About the application

Application number: 2020/93250	
What is the application for?:	Outline application for erection of residential development
Address of the site or building:	Land to the Rear of, 196, Cowlersley Lane, Cowlersley, Huddersfield, HD4 5UT
Postcode:	HD4 5UT

| TITLE                            |  |  |                       |                            |  | LARGER SITE PLAN<br>INCUKDING HAZEL COURT |  |     |  |  |  |

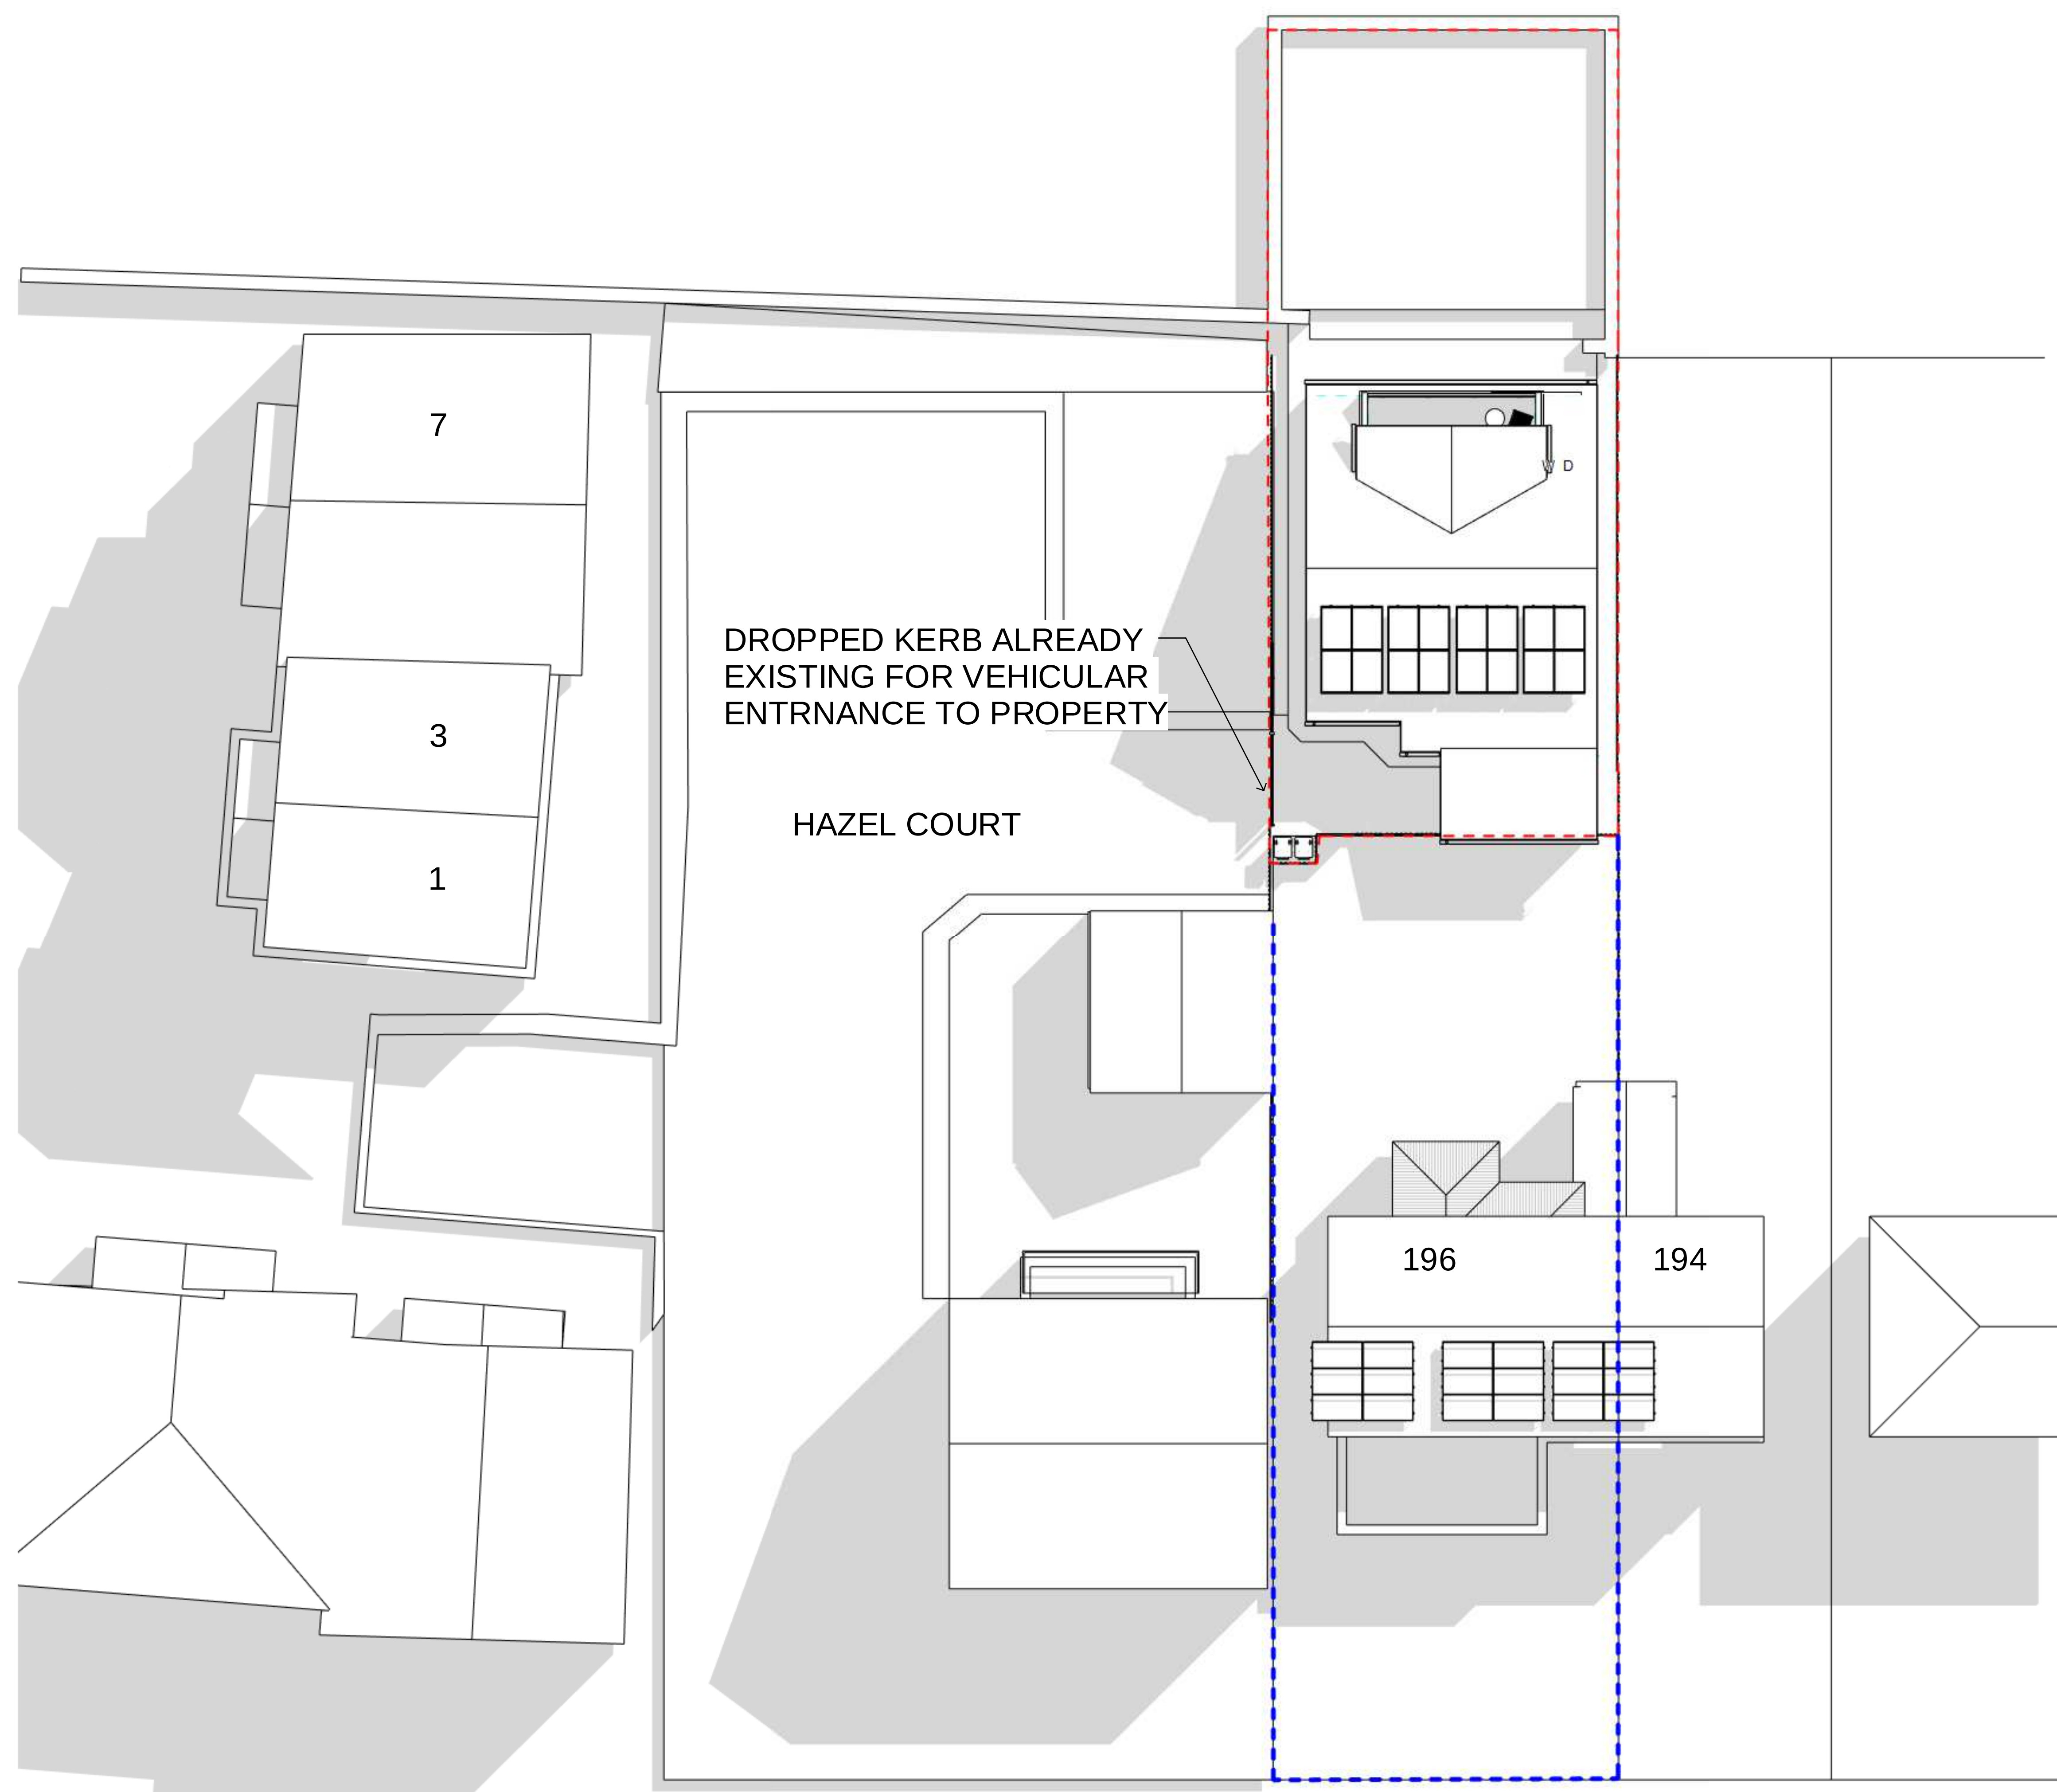
Type of comment: A general comment
1. Concerned about the height of the building, that it will block the light into our garden. 2. Boundary line. Will the building be within the permitted limit which we believe to be one metre? Can it be built up to the boundary line? 3. On looking at the plans submitted we will have 4 windows overlooking our property, 2 on the ground floor and 2 on the first floor. These will invade our privacy. 4. We were advised that the building was to be a 2 bedroomed bungalow, which we have no problem with. Unfortunately the plans show a 4 bedroomed 2 storey mansion with windows overlooking our private garden. We believe the building will obstruct our 'right to light' and the enjoyment of our garden. 5. This property will obstruct our views from our kitchen and dining room which I have enjoyed for the past 20 plus years. We confirm that we are not opposed to the building of a single storey bungalow. Please can you reply with your comments to the above points before 17 December 2020.
